WELWYN HATFIELD COUNCIL
PLANNING CONTROL COMMITTEE –27 SEPTEMBER 2007
REPORT OF THE CHIEF PLANNING AND ENVIRONMENTAL HEALTH OFFICER

S6/2007/1143/FP

ALTERATIONS TO THE SOUTHEAST EXTERNAL ELEVATION, ERECTION OF A
SMALL GROUND FLOOR EXTENSION AND NEW ENTRANCE FEATURE IN
CONNECTION WITH THE OCCUPATION OF THE PREMISES AS A DUAL
FRANCHISE AT W WATERS & SONS LTD, COMET WAY, HARPSFIELD
BROADWAY, HATFIELD

APPLICANT: WATERS RETAIL LTD

Title  
**Dual Franchise proposal**  
**Proposed Elevations**

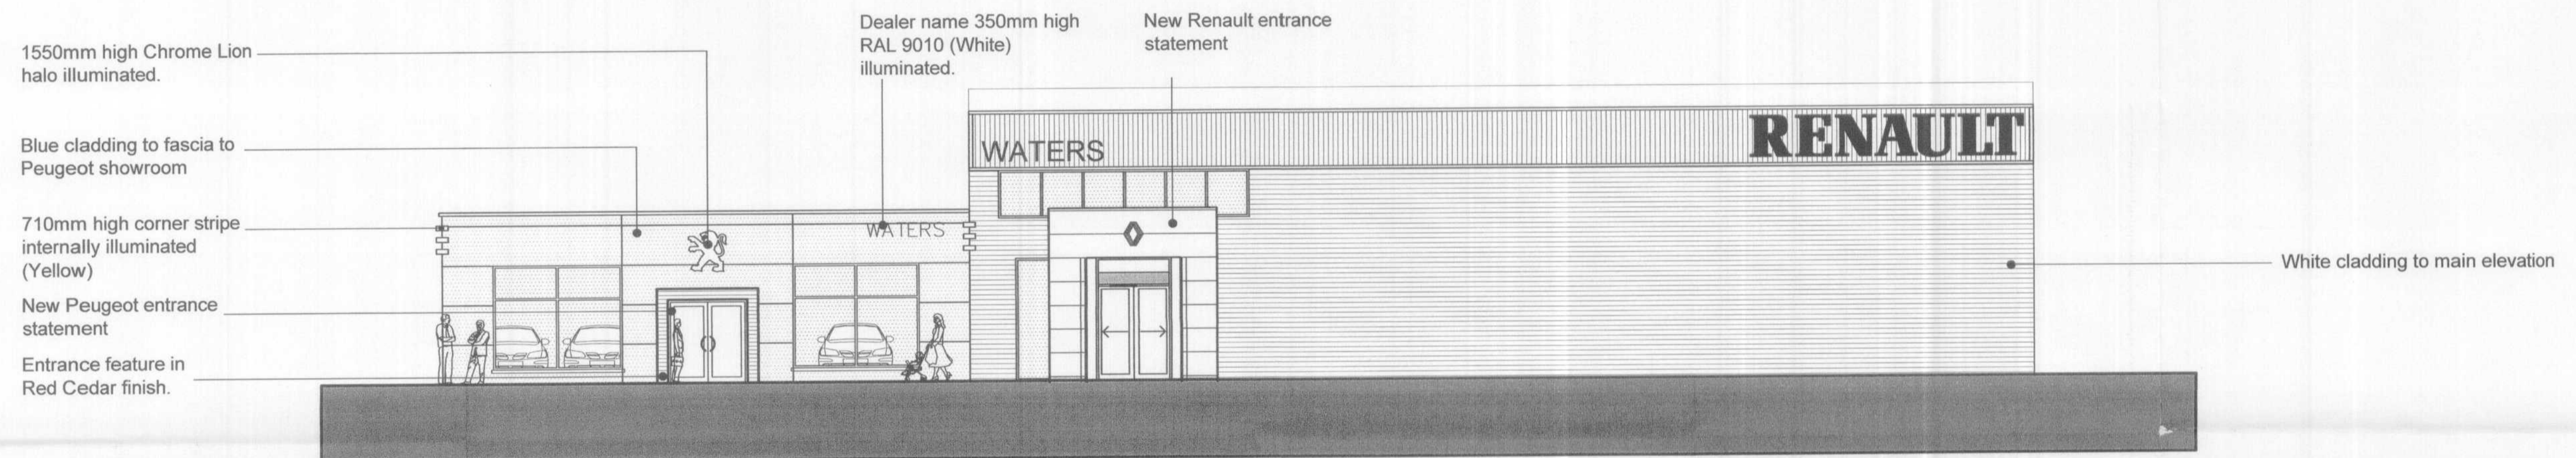
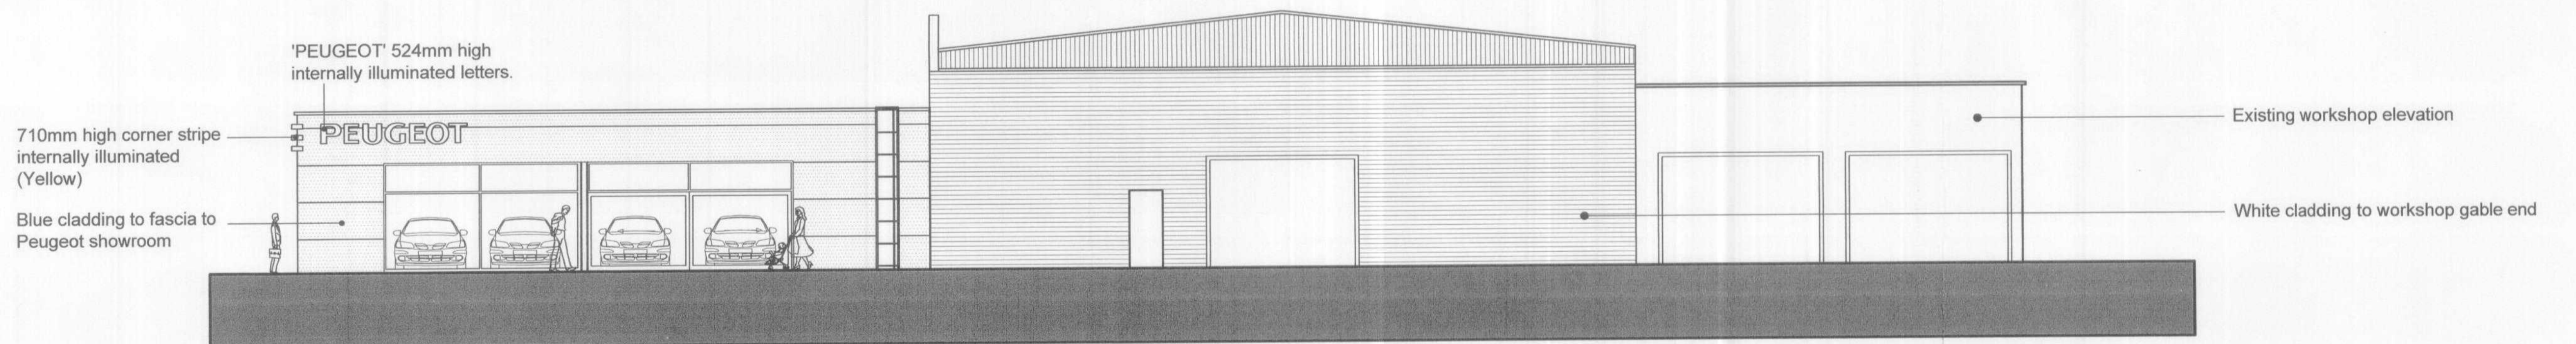
- 7.15 Policy D1 is relevant for the quality of the design proposals. The proposed changes to the external appearance of the building relate to changes relating to the cladding and entrance doorways to the individual franchises. These are considered to be in keeping with the character of the existing building. In regards to the parking layout, this is logically laid out, with customer parking to the front. In summary the proposal complies with the design requirements subject to a planning condition requiring the submission of samples.

1. C.2. 1 – Time Limit for Commencement of Development.
2. C.5.1 – Samples of materials to be submitted.
3. C.8.20 – Cycle Parking Provision.
4. Notwithstanding the details shown on approved drawing No R29389/100 Rev C (received and date stamped 31/07/07) an amended parking layout plan to an appropriate scale shall be submitted to the Local Planning Authority showing the provision of 4 parking spaces for the sole use of employees. These spaces shall be marked out on site and also clearly annotated for this use and shall be agreed in writing by the Local Planning Authority prior to first occupation of the new showrooms hereby permitted and shall remain in that form thereafter.
